Subject: Review Comment Response  
Geologic Hazards Evaluation  
Preliminary Geotechnical Investigation  
Crossroads North  
Marksheffel Road and State Highway 24  
El Paso County, Colorado  
Project No. CS18526.001-105

This report letter presents our response to the Colorado Geological Survey (CGS) review comments regarding our Preliminary Geotechnical Investigation. The following discussion provides specific items from the CGS comments and our responses.

CROSSROADS NORTH PRELIMINARY GRADING PLAN

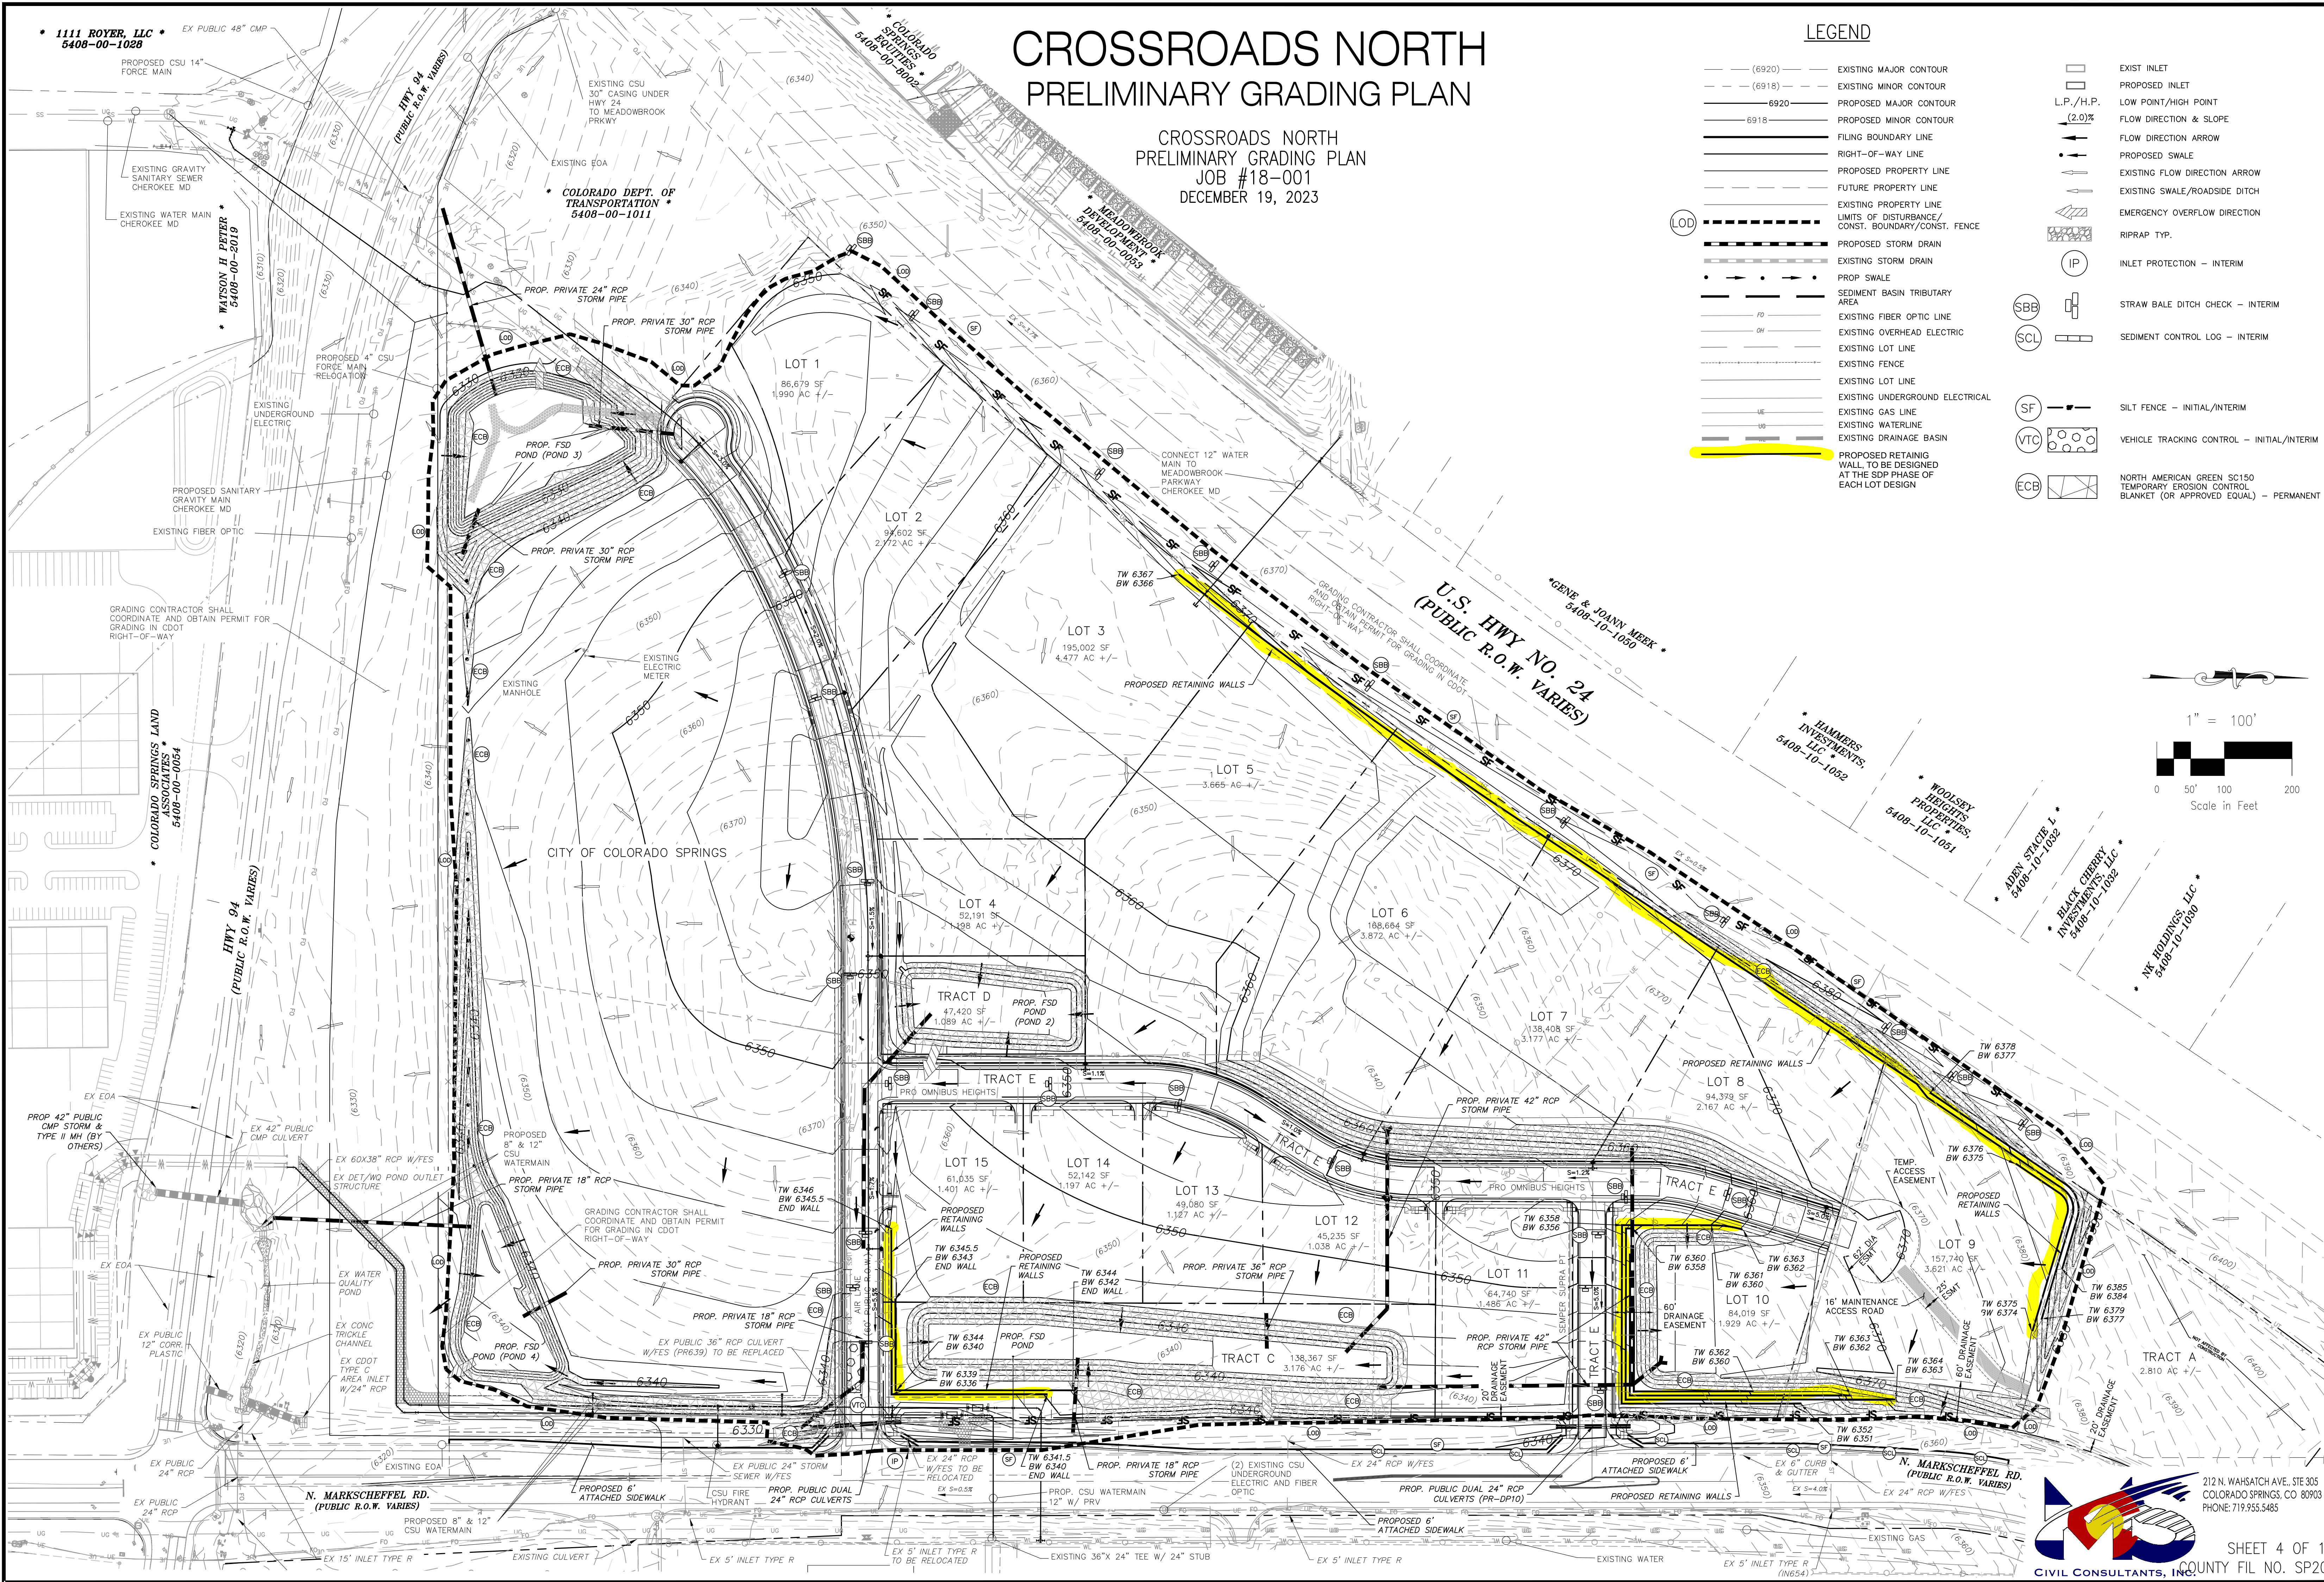
“CGS received grading plans with this submittal, while CTL|Thompson indicated they did not review such plans. CGS recommends that the county or developer provide CTL|Thompson with grading plans, and they review the plans for conformance with the geotechnical report recommendations. The geotechnical report states that eolian soils underlie the site. Once wetted and loaded, such soils can settle and cause damages to buildings, pavements, and other infrastructure. CTL|Thompson indicates that the risks to proposed structures form hydrocompactive soils are low for lightly to moderately load structures (one to two-story buildings). The report contains limited soil testing to determine the risk or degree of the potential of hydrocompaction.”

We have received the preliminary grading plans from Kimley-Horn. As the CGS notes, the sands that underlie the site have the potential to be hydro-compactive. Based on the testing data available on the site the soils classify as having low to moderate collapse potential using the criteria from CGS publication EG-14 “Collapsible Soils in Colorado,” Fig. 4-13. The soils with the higher potentials are generally spread across the site. Limited testing was preformed because the lack of fines and low moisture contents in the natural sands precluded

We provided a brief discussion of possible mitigation options in our report. Based on the preliminary grading plans portions of the site will have significant amounts of fill in excess of 15-feet. Deep fill could help mitigate potential differential movements if settlement of natural soils were to occur below the fill. The possible presence of potentially hydro-compactive soils should be further addressed at the time of the design level reports. We did not find any contradictory conditions based on our review of the preliminary grading plans, and hold that the findings of the Preliminary Geotechnical Investigation and Geologic Hazard Evaluation remain valid for the site.
